Recommendation Report for Planning Permission for Works or Extension to a Dwelling

REF NO: M/30/25/HH

LOCATION: Sea Holly
4 South Walk
Middleton-on-Sea
PO22 7RW

PROPOSAL: Proposed extension to existing rear dormer.

Drawing Title: **DORMER EXTENSION**

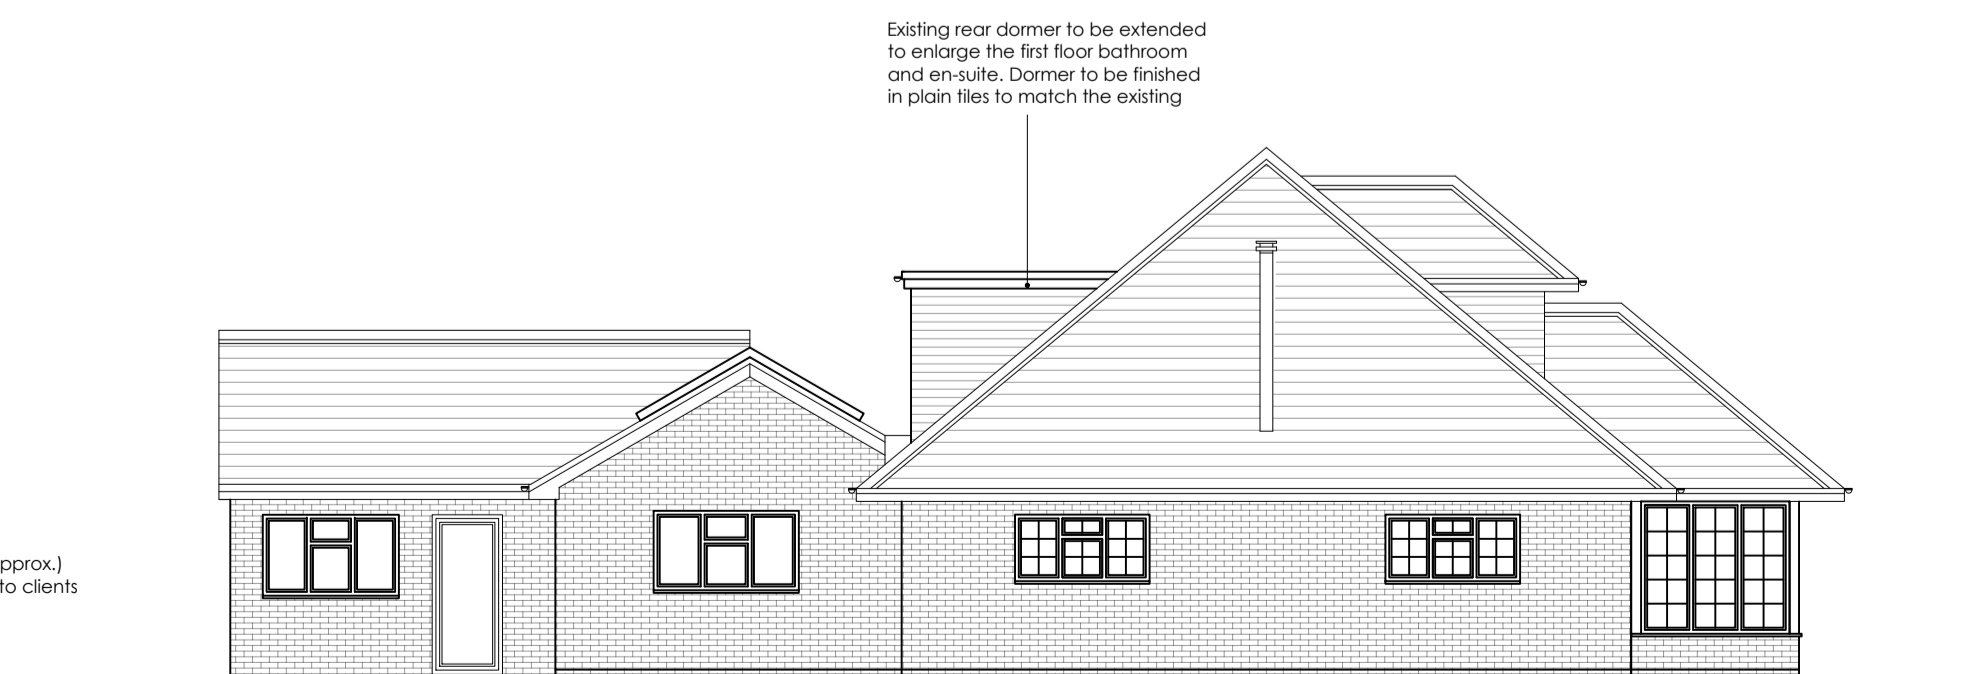
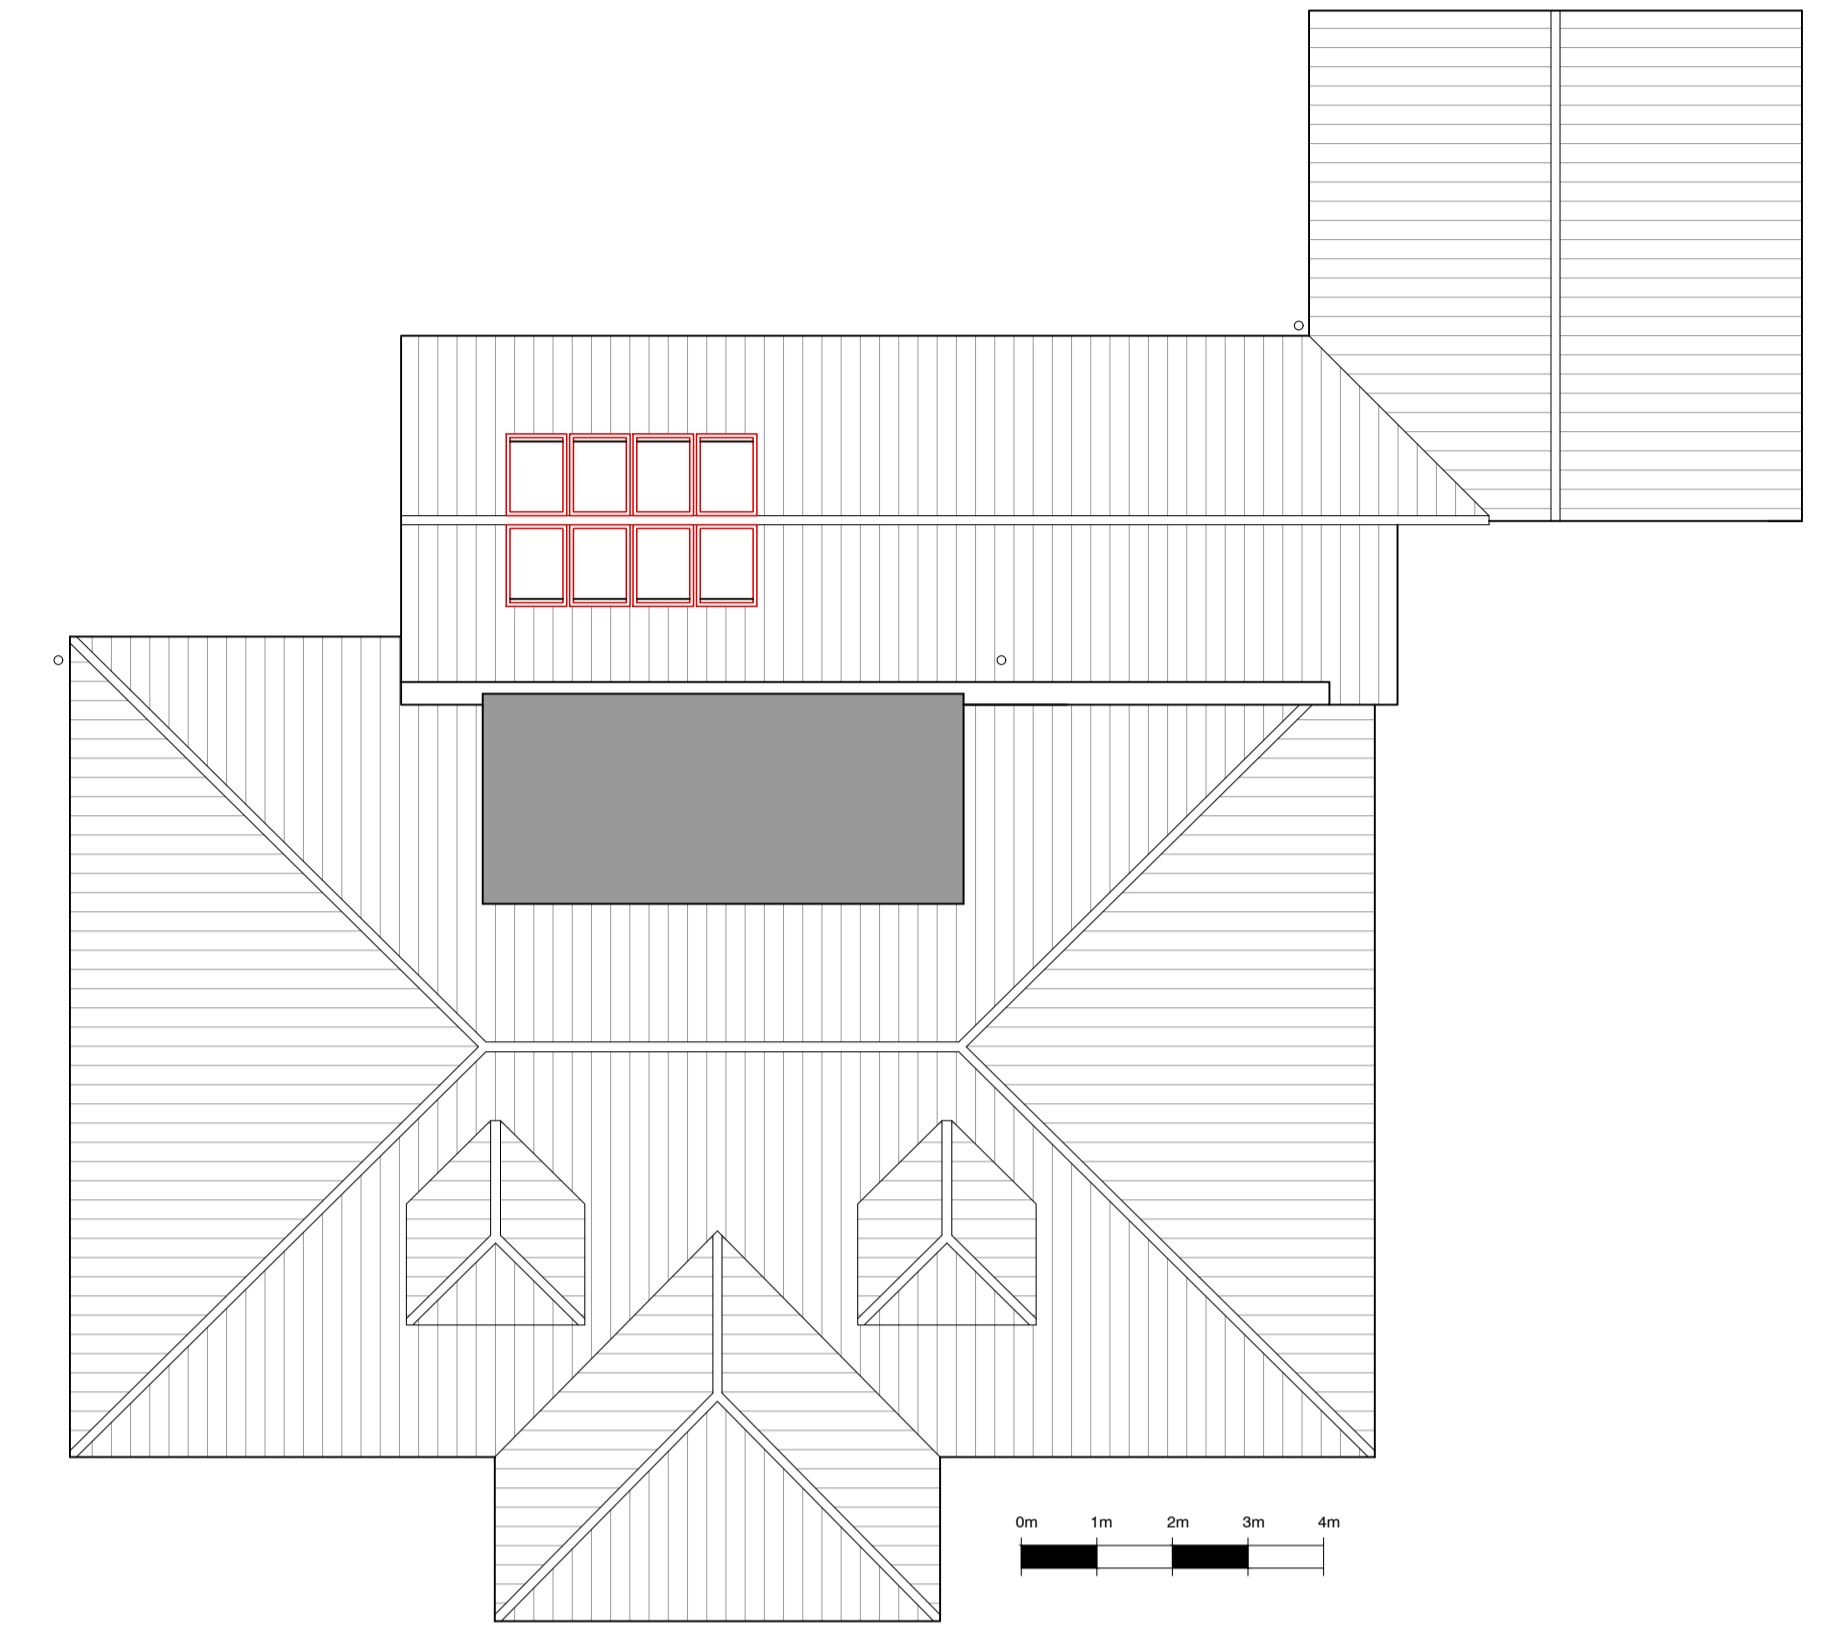
The existing rear dormer is to be extended to enlarge the bathroom and en-suite area at first floor level. The depth of the rear dormer would be increased by 1.3m, the width of the rear dormer will remain the same. As such, the proposal would be a minor alteration to the scale of the rear dormer. Given the minor scale of works the proposal would not result in the dwelling appearing out of keeping with the area and is acceptable. The walls of the proposed dormer extension would use the same materials and the dormer would maintain the same profile and width as the existing dormer. Due to the scale and design of the proposed extension of the dormer and the proposed materials and finishes, the proposal is subservient and sympathetic. The proposed dormer extension is in accordance with section M of the Arun Design Guide and policy D DM1 and D DM4 of the Arun Local Plan (ALP).

The rear dormer would partially conflict with the Arun Design Guide (ADG), which states that dormers should be minor incidents on the roof plane and incorporate pitched roofs in most cases, avoiding large box-shaped designs. It is noted that the rear dormer would be minimally set up from the eaves height of the dwelling following the proposed extension, however given that there is an existing rear roof slope obscuring views of this dormer, it is acceptable. Additionally, in this instance, there is an existing wide, flat roof dormer and there are other examples of similar dormers to that proposed on the street scene. Therefore, the proposed dormer extension would not appear prominent within the street scene, nor result in harm to the character of appearance of the host dwelling.

Additionally, a set of six rooflights are proposed to the roofscape of the rear (north) roof of the dwelling. These rooflights are high level and given that there already 4 rooflights, (two of smaller scale) are present along the rear roof, the additional rooflights are acceptable given their minimal visibility from the street scene. Along the rear (north) elevation, two sets of three-pane bifold doors are proposed, measuring approx. 5.3m in width. Given that the doors are set in 24m from the rear site boundary, the works would not adversely impact the character of the area.

The proposed rear dormer extension would contain 2no. windows which would be larger than the windows within the existing dormer but lesser in number. The overlooking effects across neighbouring properties would be similar to the level already experienced by nearby occupants and would not be materially intensified by the development. The dormer is contained within the footprint of the existing building and would be set in 24m from the rear site boundary. As such, the extension to the dormer would not result in overbearing or overshadowing to neighbouring properties.

A set of six rooflights are proposed to the roofscape of the rear (north) roof of the dwelling. These rooflights are high level and would not result in overlooking. The bifold doors are set in front the rear site boundary by 24m and overlook the rear garden amenity and are acceptable.

- 3 The materials and finishes of the external walls of the rear dormer extension hereby permitted shall match in colour and texture those of the existing building.
